Inspections - Re: 20 University St. Portland, ME Permit

From: Inspections
To: Andrew Gervais
Date: 4/20/2016 9:43 AM
Subject: Re: 20 University St. Portland, ME Permit

University Remodel
Elevations
Portland, ME

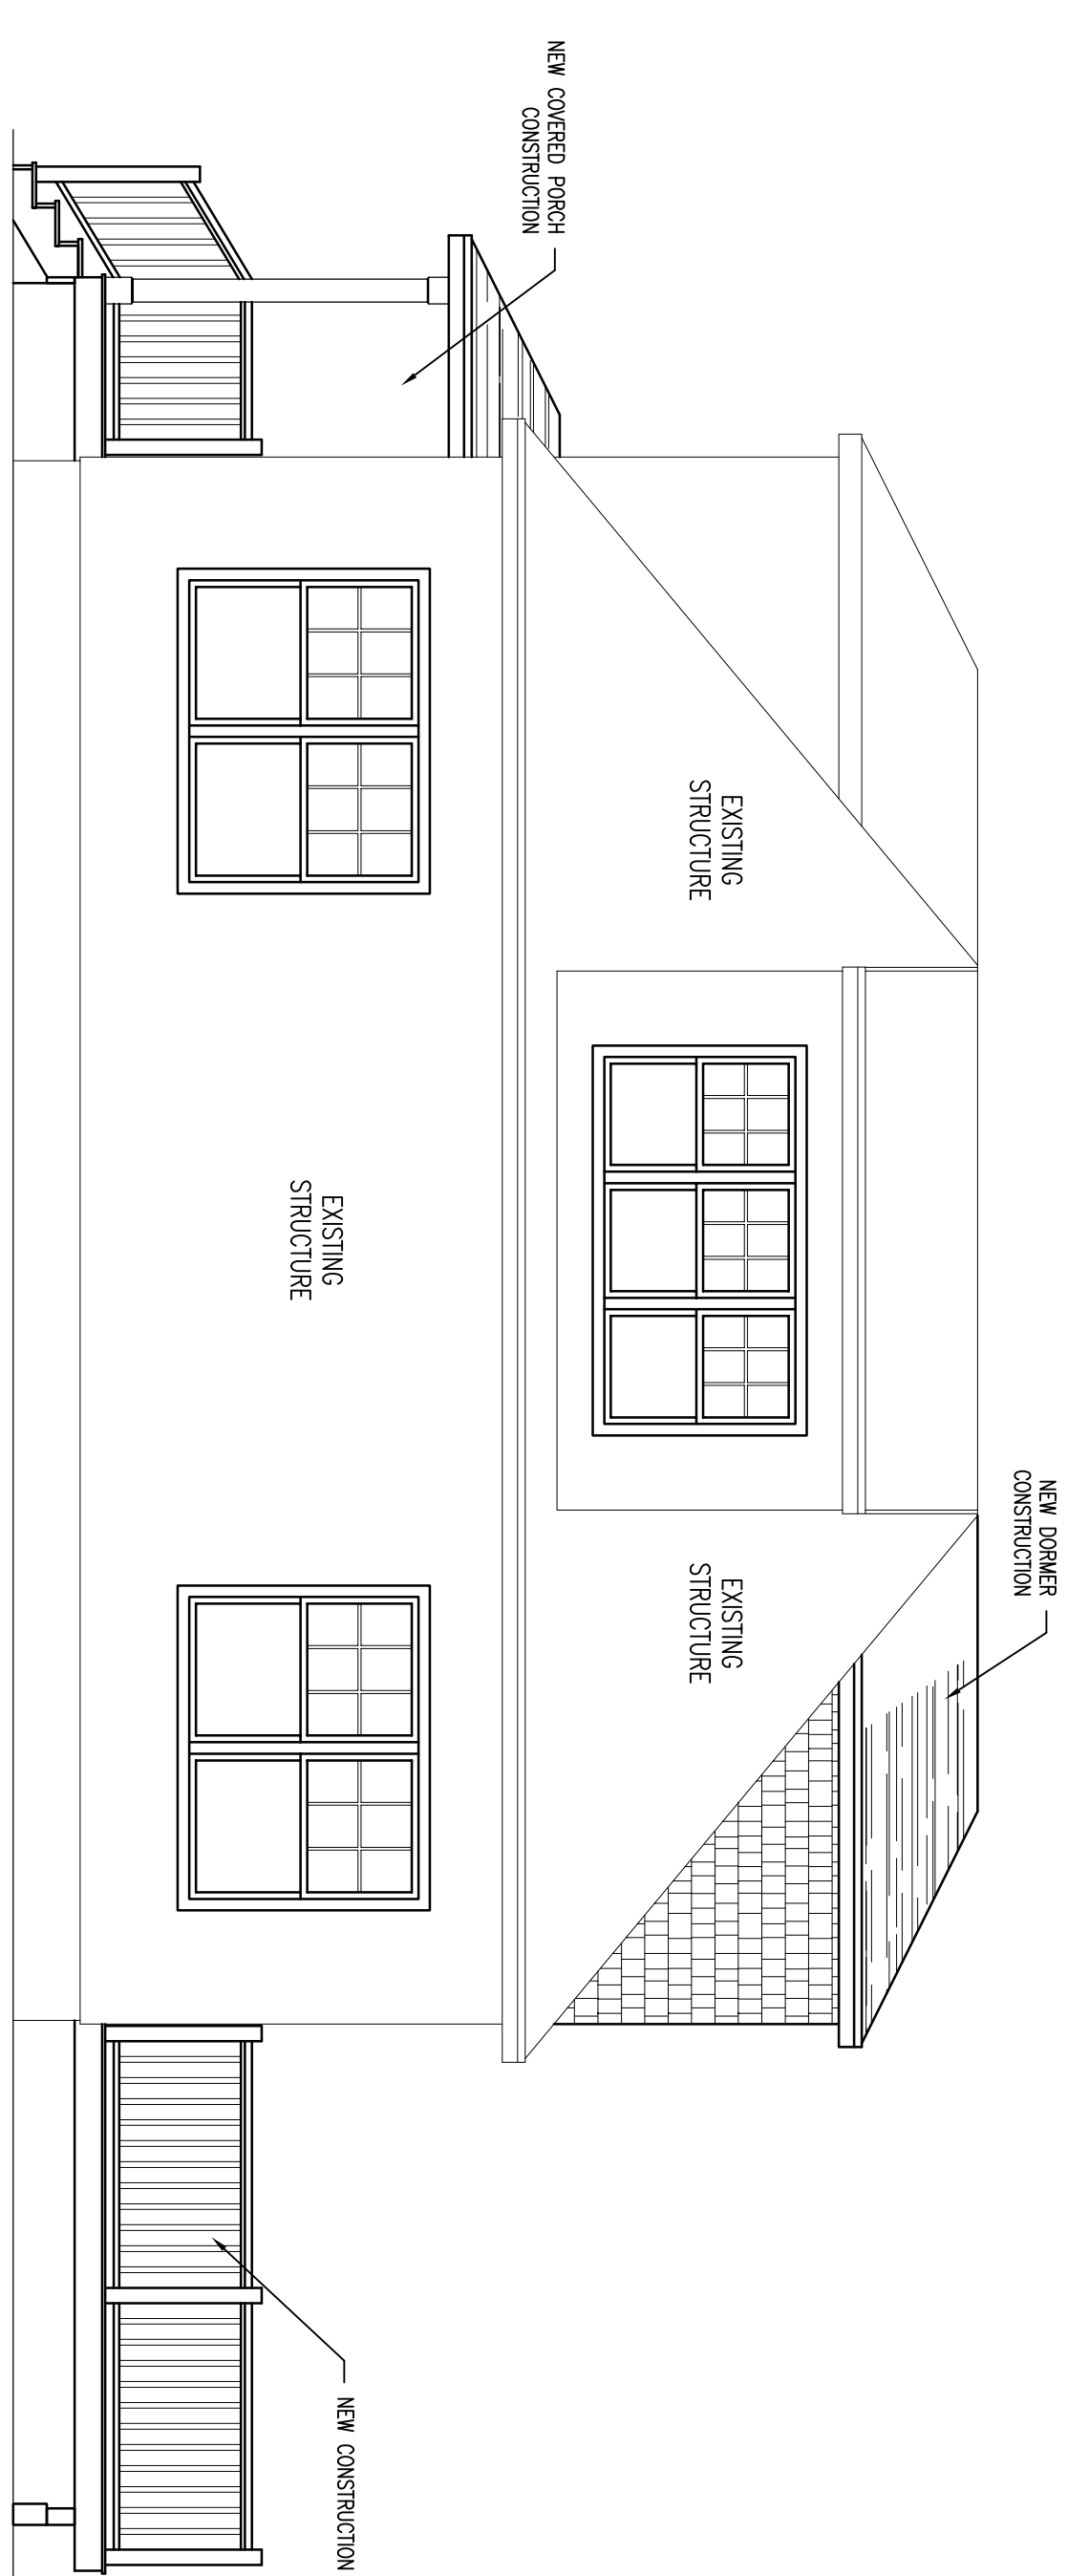
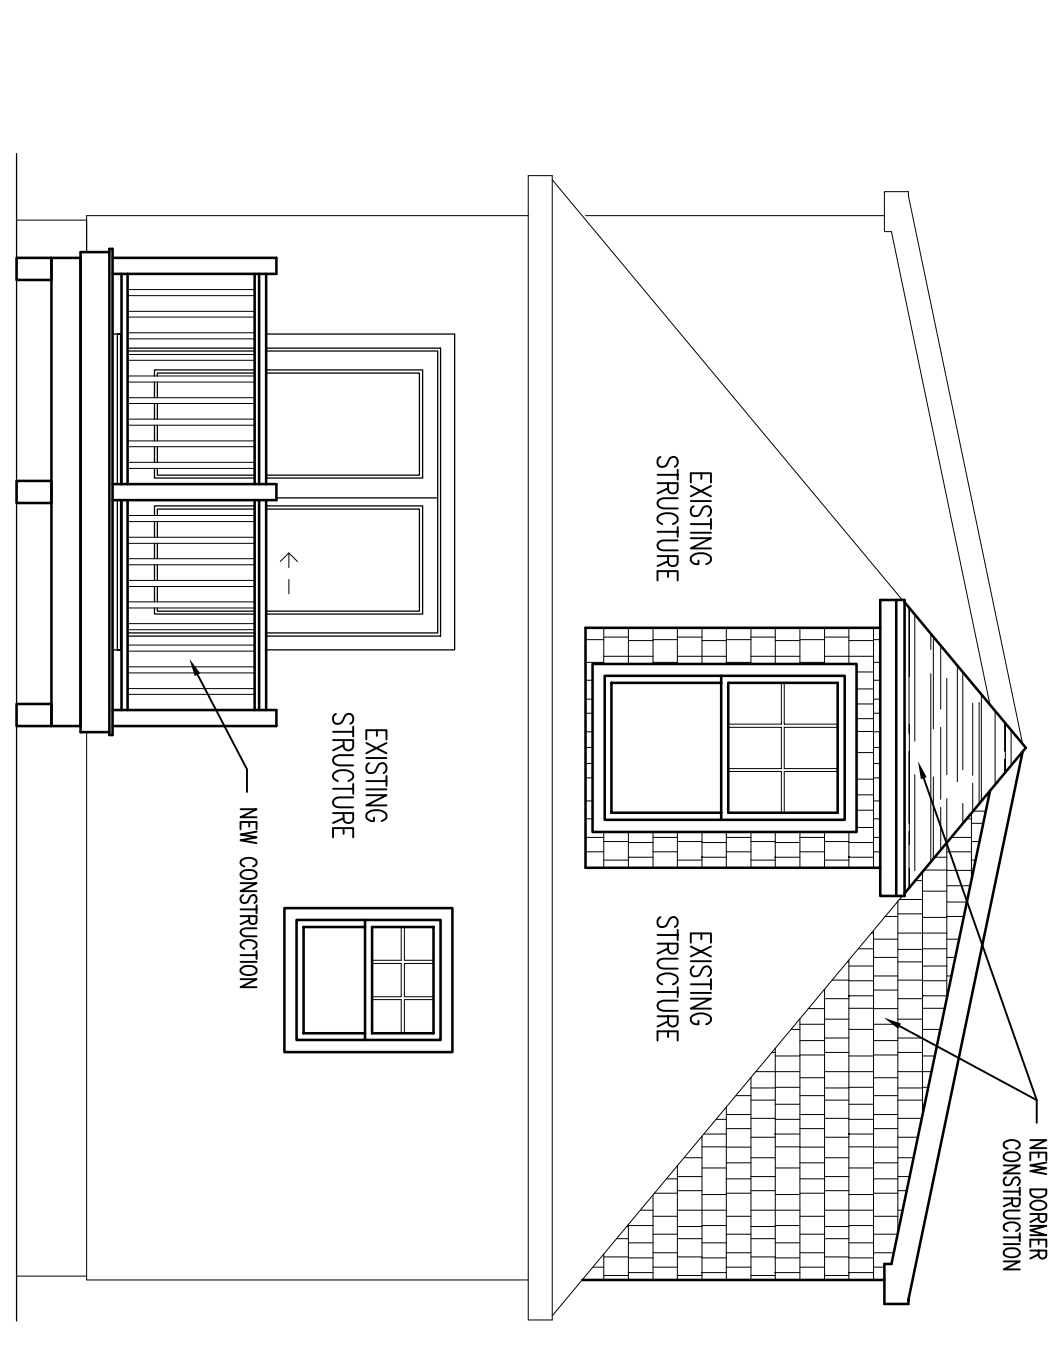
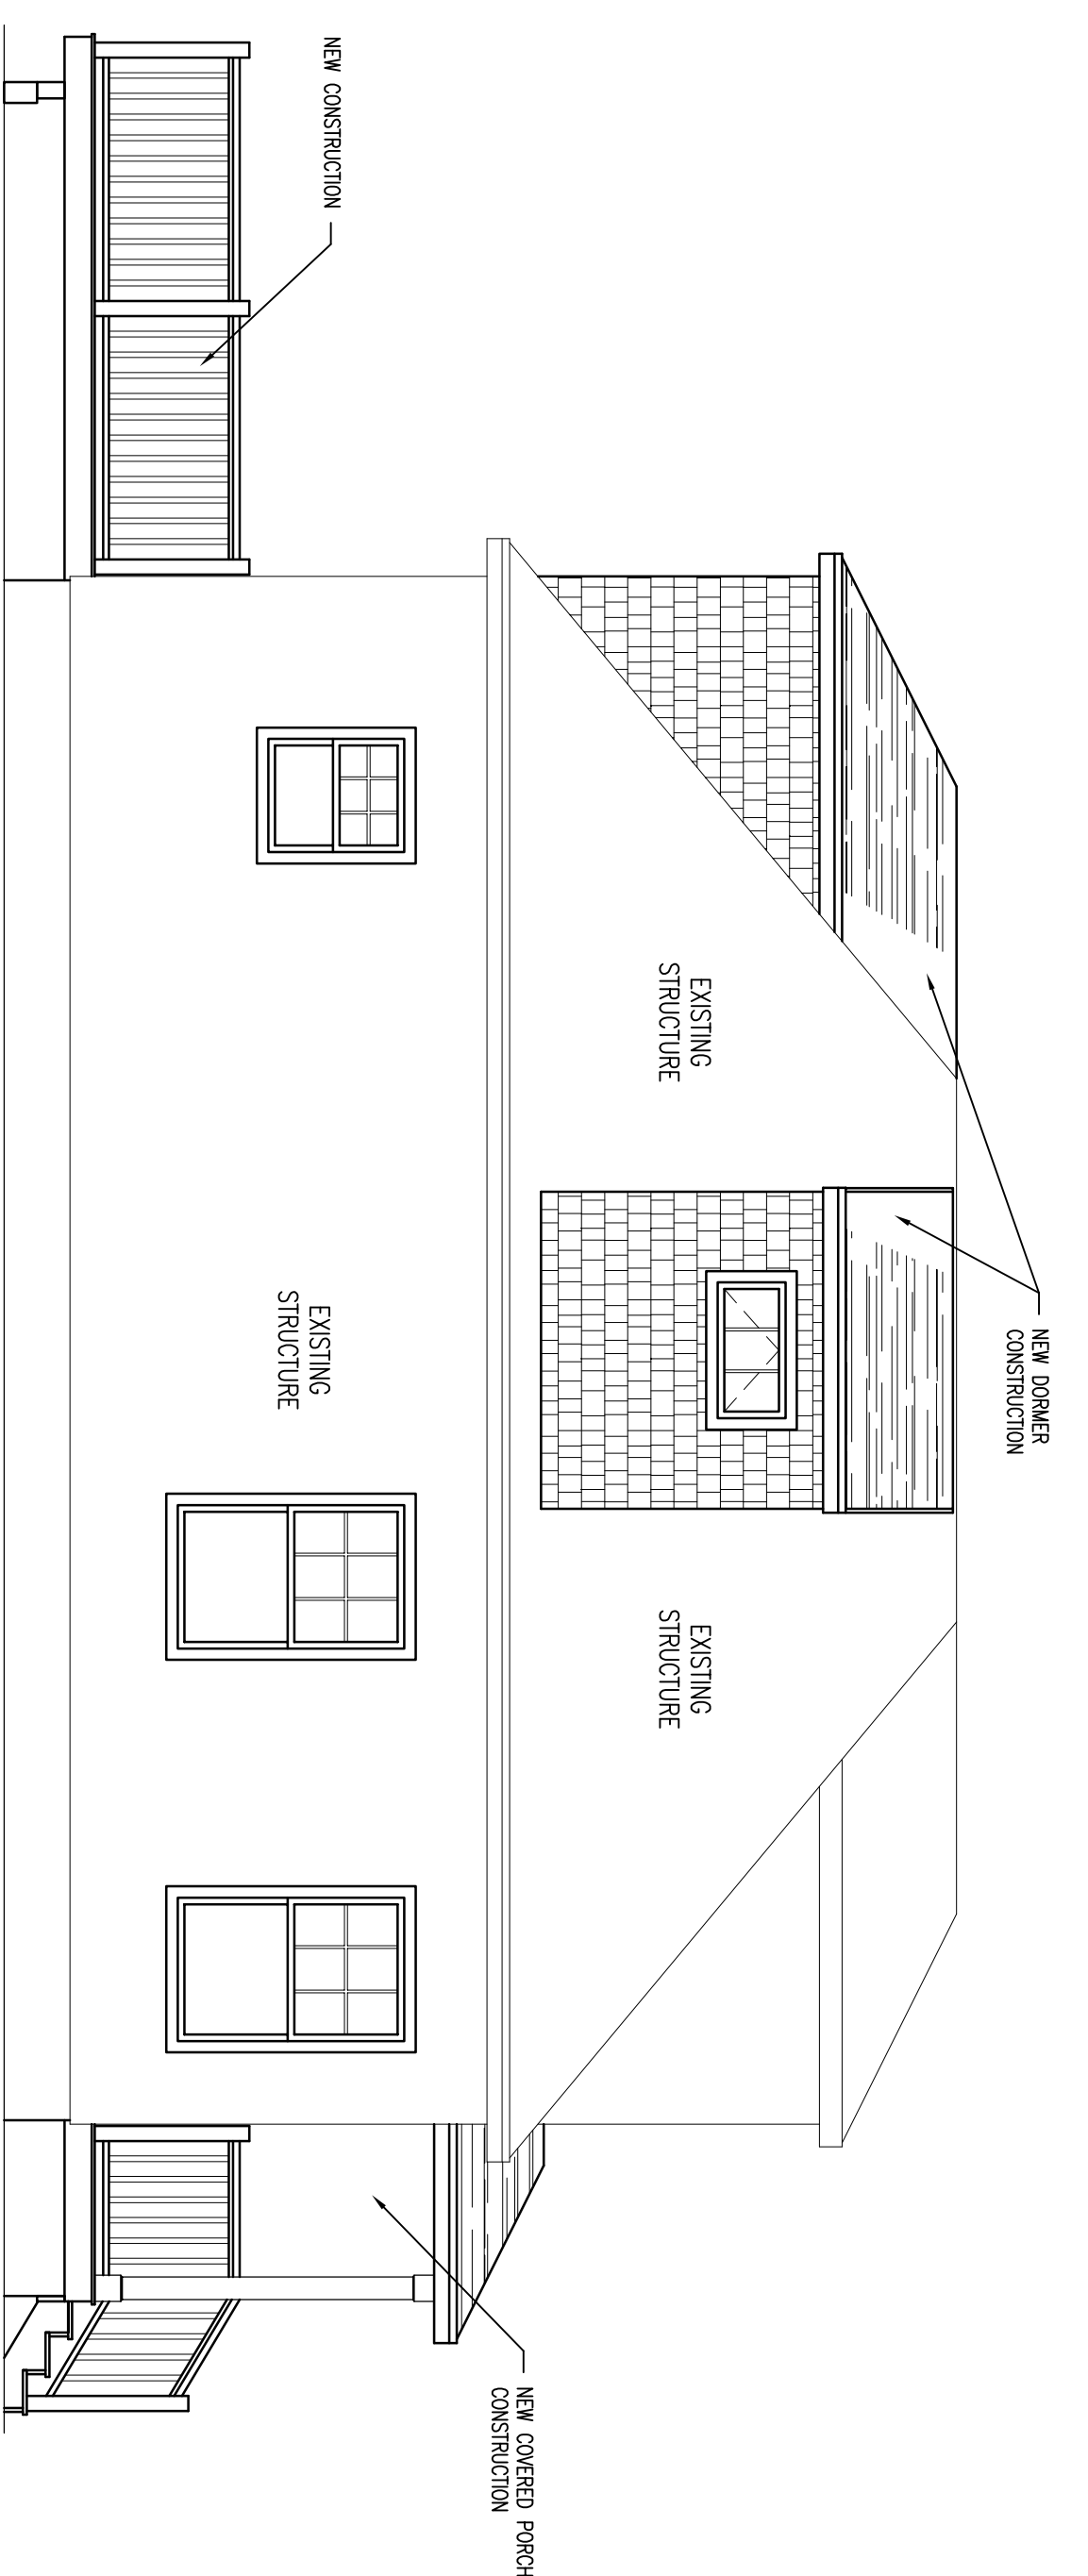
In reviewing all the documents you sent; it looks like you are constructing a dormer, which is not fast trackable (unless you get all the plans stamped by a design professional.) Your plans are also insufficient in the constructing of that dormer. You need to provide cross section with framing details, etc as required in the checklist.
